### Response to Planning Application

**From:** Arun District Council Leisure & Greenspace

**Application ref:** AL/11/24/OUT

**Location:** Land East of Westergate Westergate

Combined Illustrative Masterplan

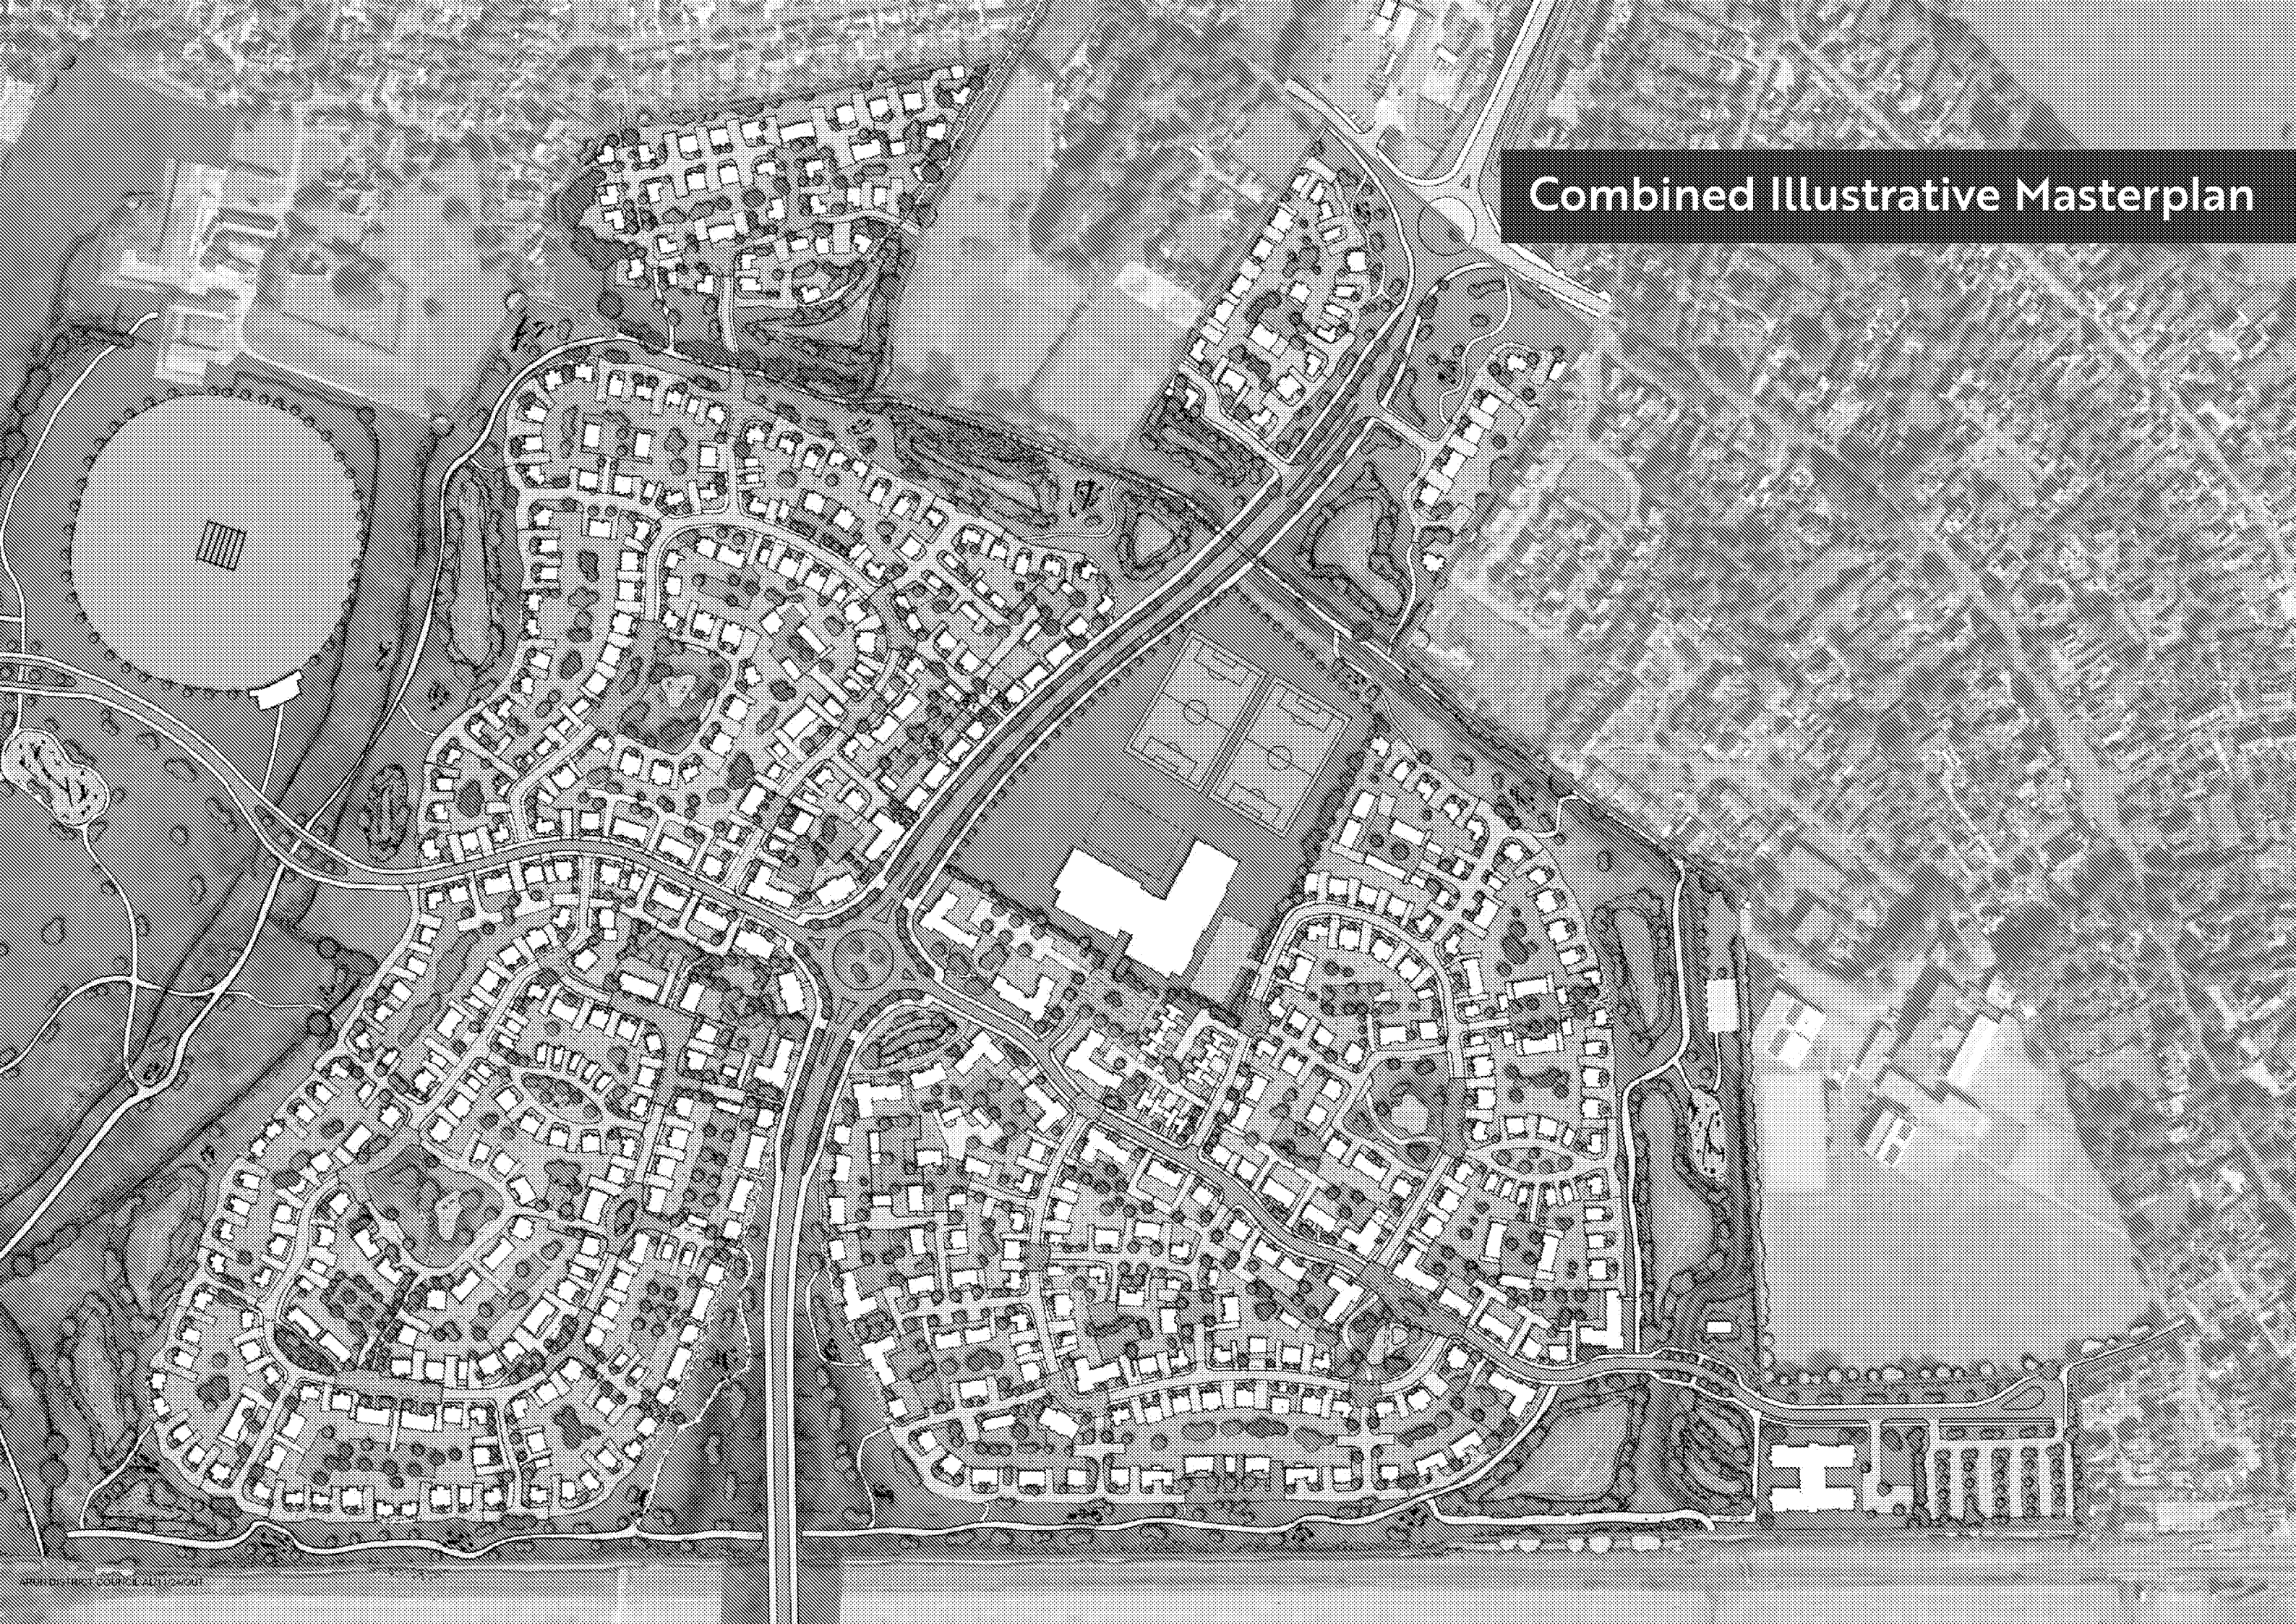
provision. Play will need to accord to a general site wide theme, be accessible and inclusive and required in detailed plan form so that the concept and proposal can be adequately assessed. **The Masterplan would seem to indicate only 1no LEAP and 3no LAPS being proposed which would appear to be under provision in line with policy.**
